December 2, 2016

SUBJECT: **Modification Request of Section 404 Regional General Permit No. 31 and Section 401 General Water Quality Certification No. 3886** for the proposed Interstate 85 (I-85) Widening and Interchange Improvements from north of NC 73 (Davidson Highway / Exit 55) to north of SR 2180 (Lane Street/Exit 63), Cabarrus & Rowan Counties, Divisions 9 and 10. Federal Aid Project No. FANHIMF-085-2(61)55, TIP Project No. I-3802A.

The permit drawings for these three sites have been revised to depict the additional bank stabilization at Site 2, temporary impacts at Site UC-1, and the additional bank stabilization at Site 18. They have been included in this modification request along with the revised impact summary tables.

PROJECT REFERENCE NO. I-3802A	SHEET NO. 17
RW SHEET NO. ROADWAY DESIGN ENGINEER	HYDRAULICS ENGINEER
BLYTHE

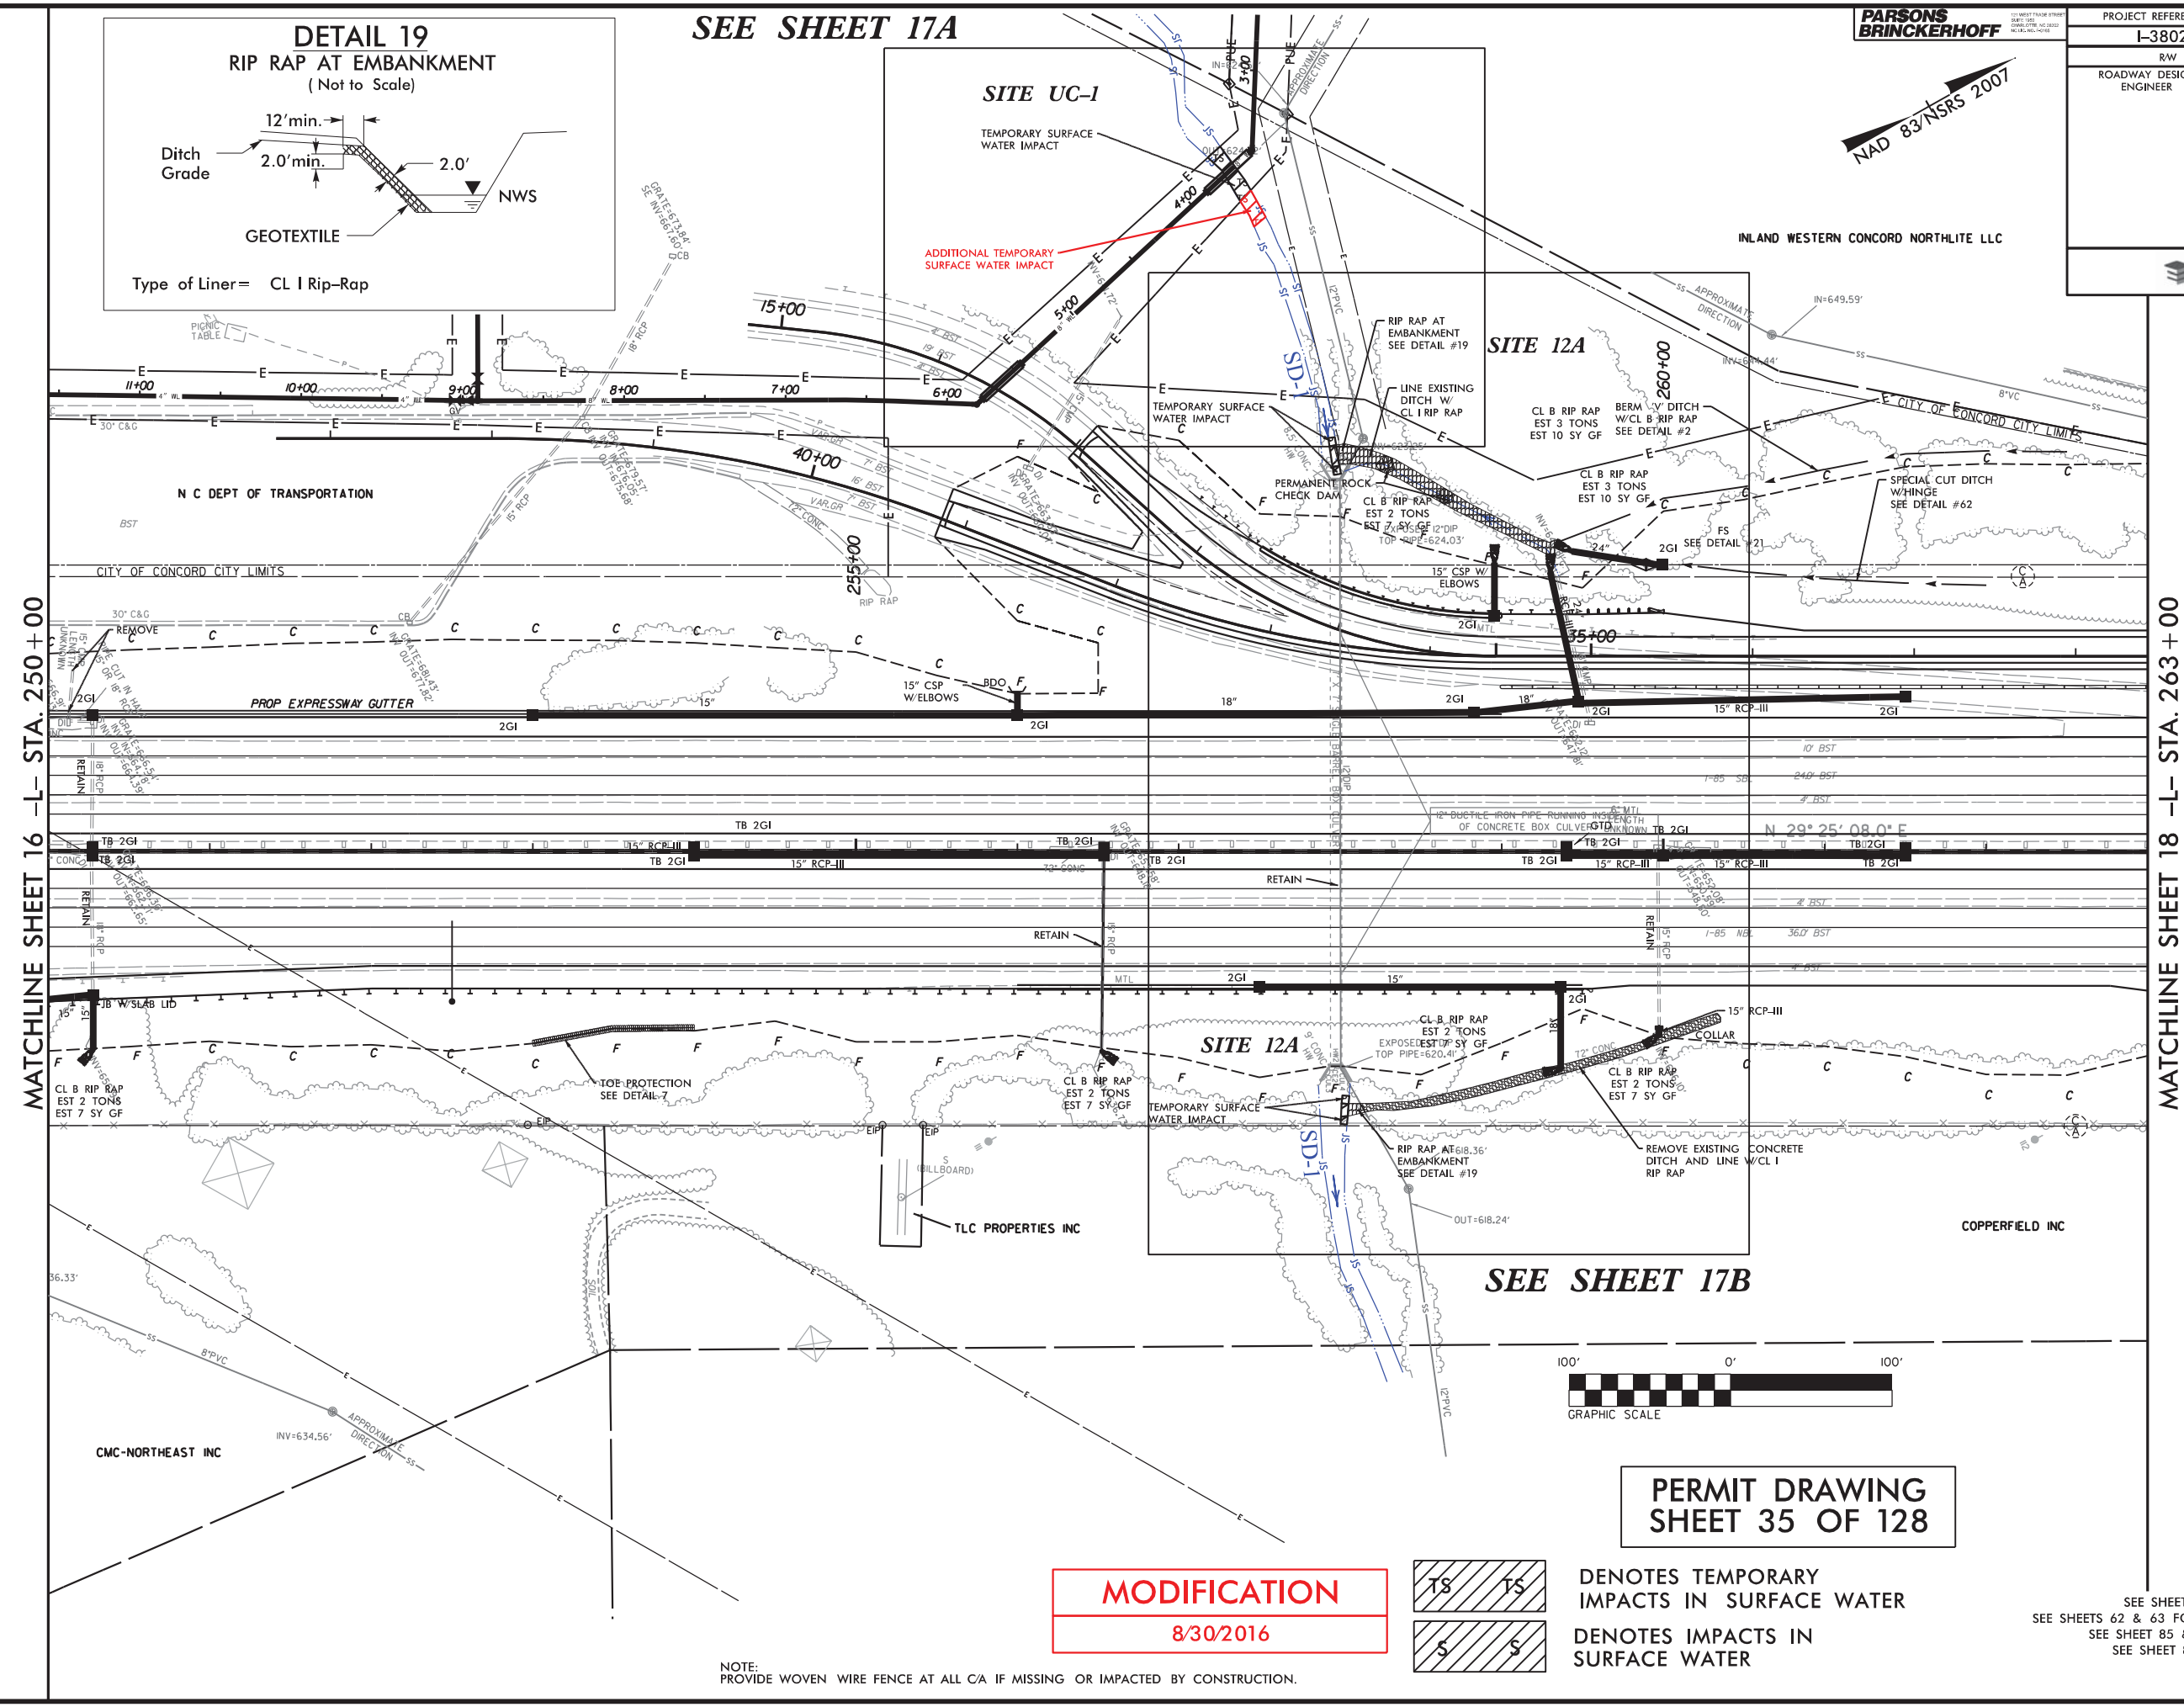
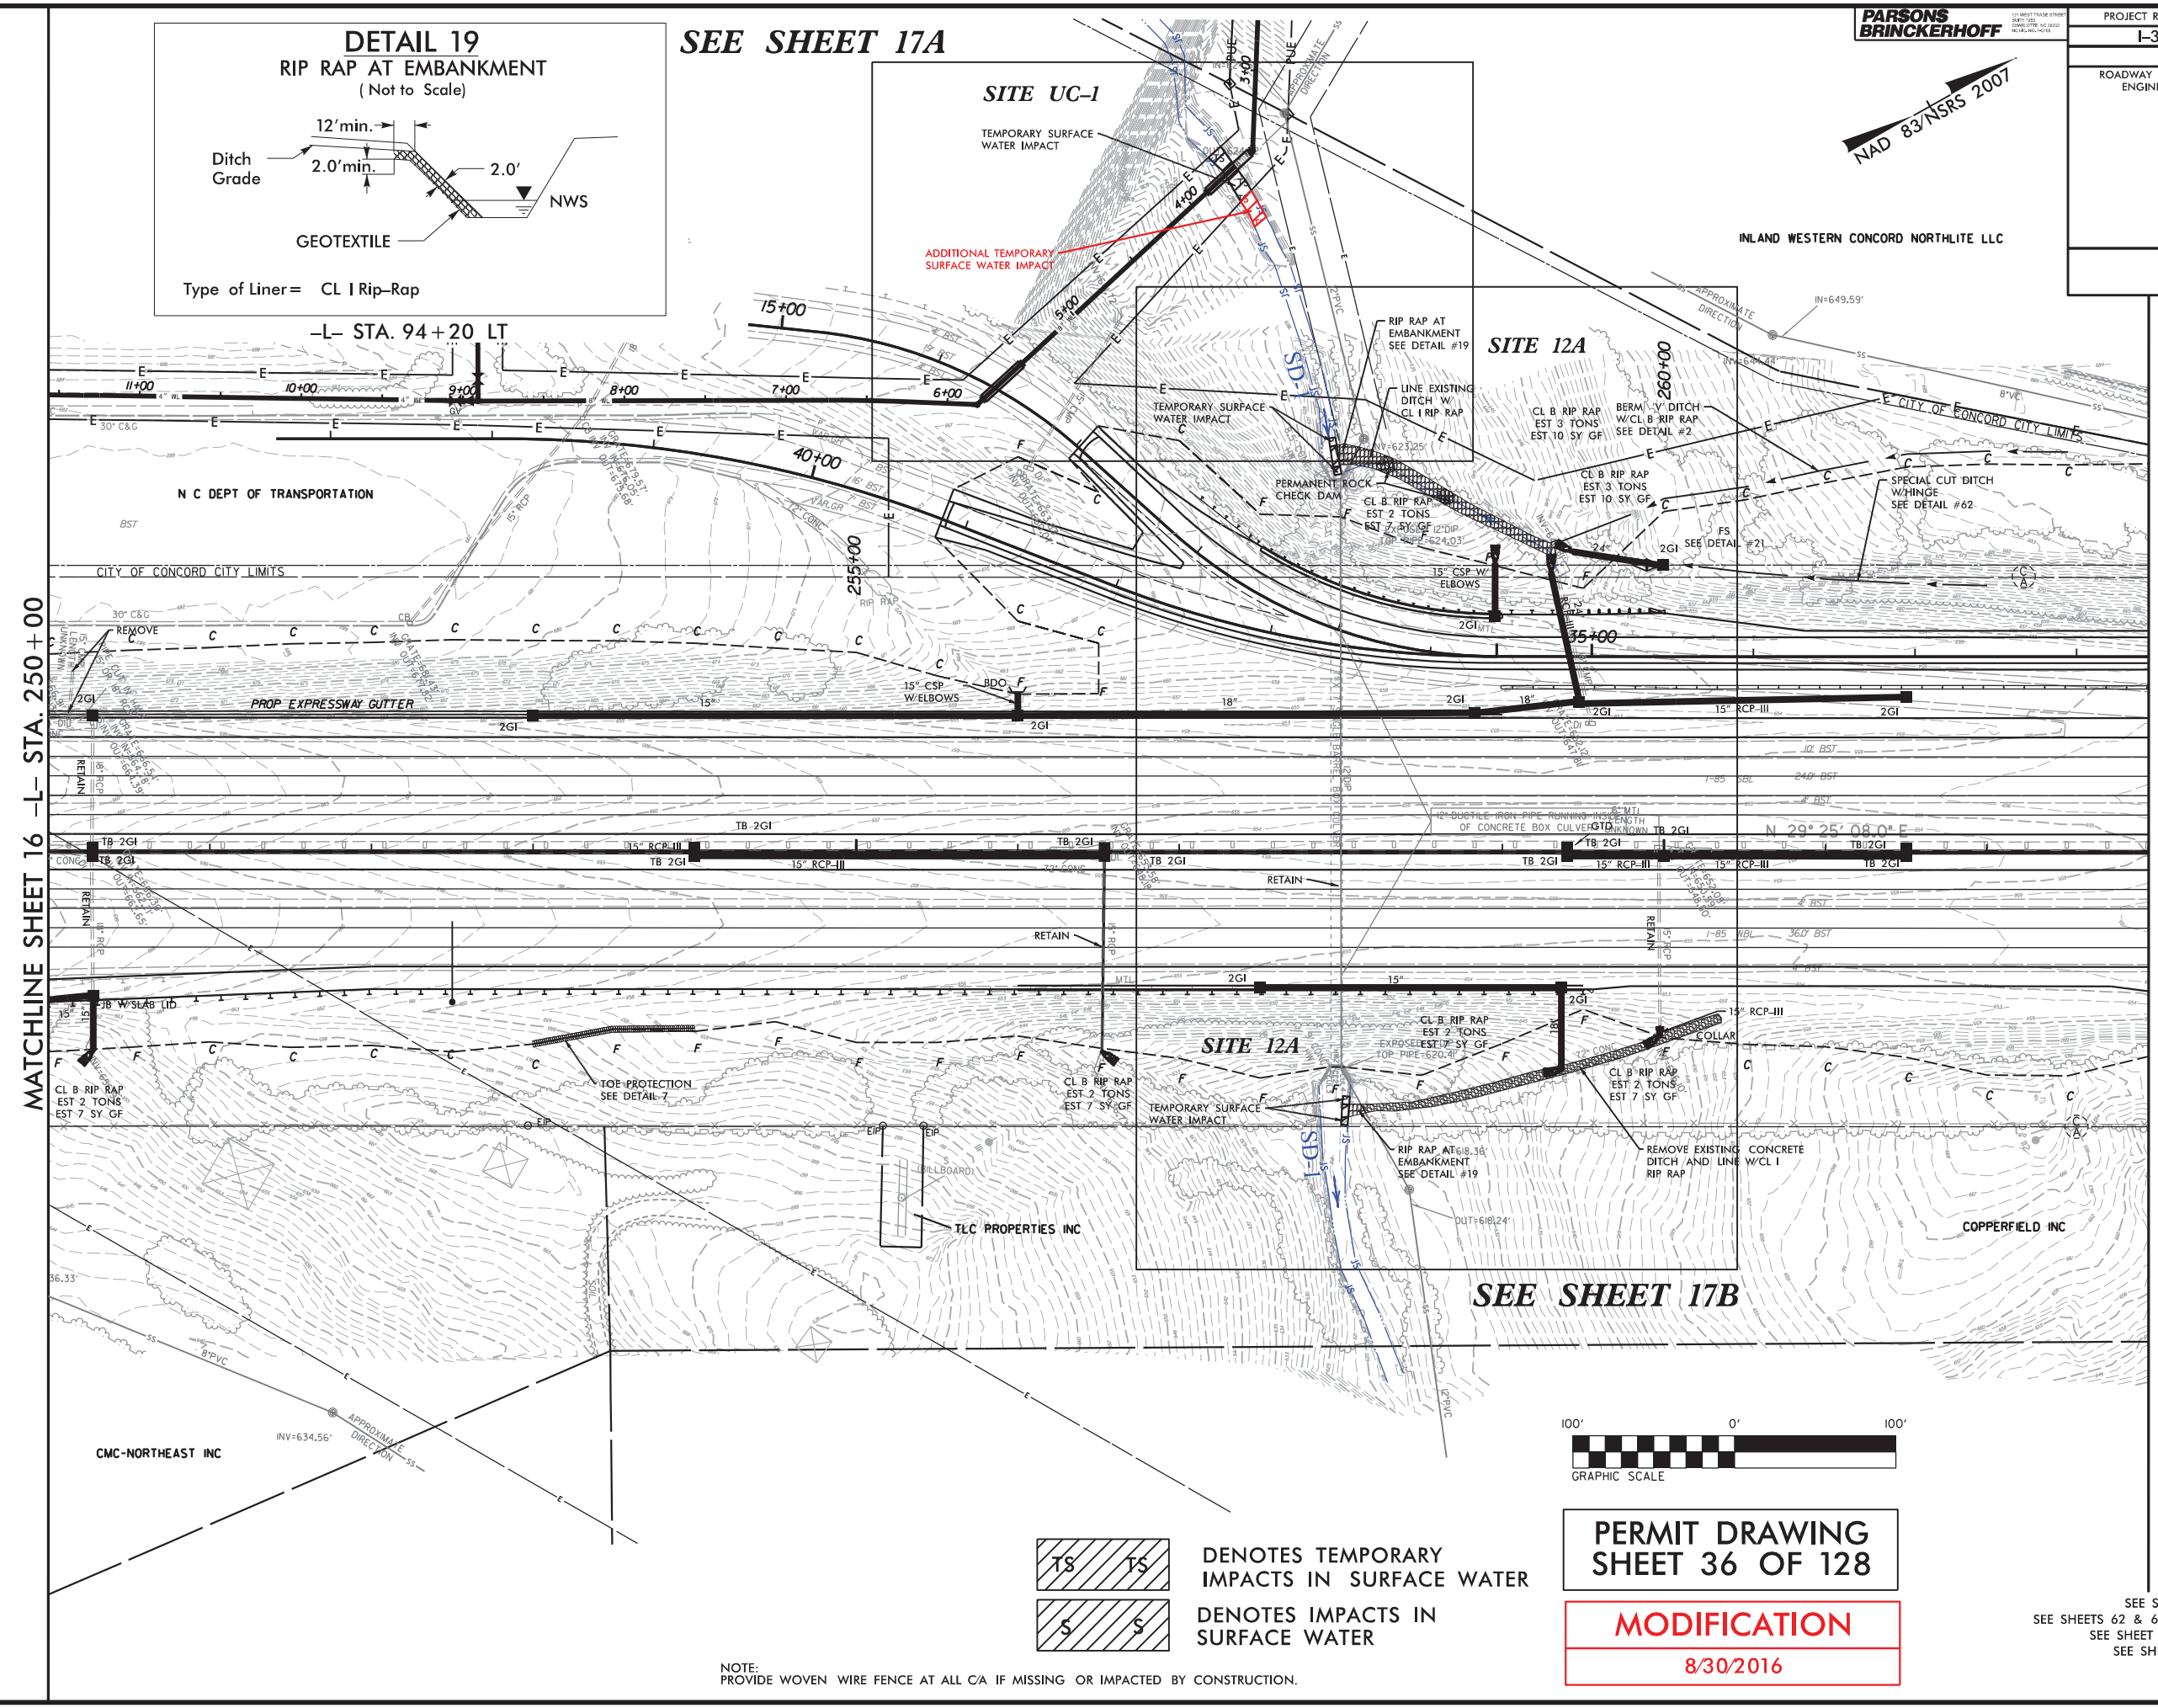
On July 19, 2016, representatives from NCDOT met on site with Ms. Donna Hood to conduct a project review. During the site meeting Ms. Hood measured additional unpermitted temporary impacts of approximately 16 feet in length to Site UC-1. During the site prep for the installation of the proposed waterline, additional areas were cleared along the stream banks. The clearing impacts were necessary for the installation of the waterline and to allow for a dry work area. Ms. Hood recommended that these additional impacts be included in the next permit modification. Ms. Hood contacted Ms. Crystal Amschler (USACE) via email on September 21, 2016 to inform her that she had observed the aforementioned impacts and had made recommendations to the contractor regarding a time frame for submission of the modification request.

The temporary surface water impacts associated with the waterline installation overrun resulted in an additional 19 linear feet of temporary stream impact per the contractor's field measurements (this is the same area as the 16 feet referenced above, but a more

accurate measurement). The proposed impact total for Site UC-1, including the previously-permitted impacts and the currently unpermitted impacts are 56 linear feet of temporary stream impacts. No other changes to permitted wetland and stream impacts are proposed for Site UC-1.
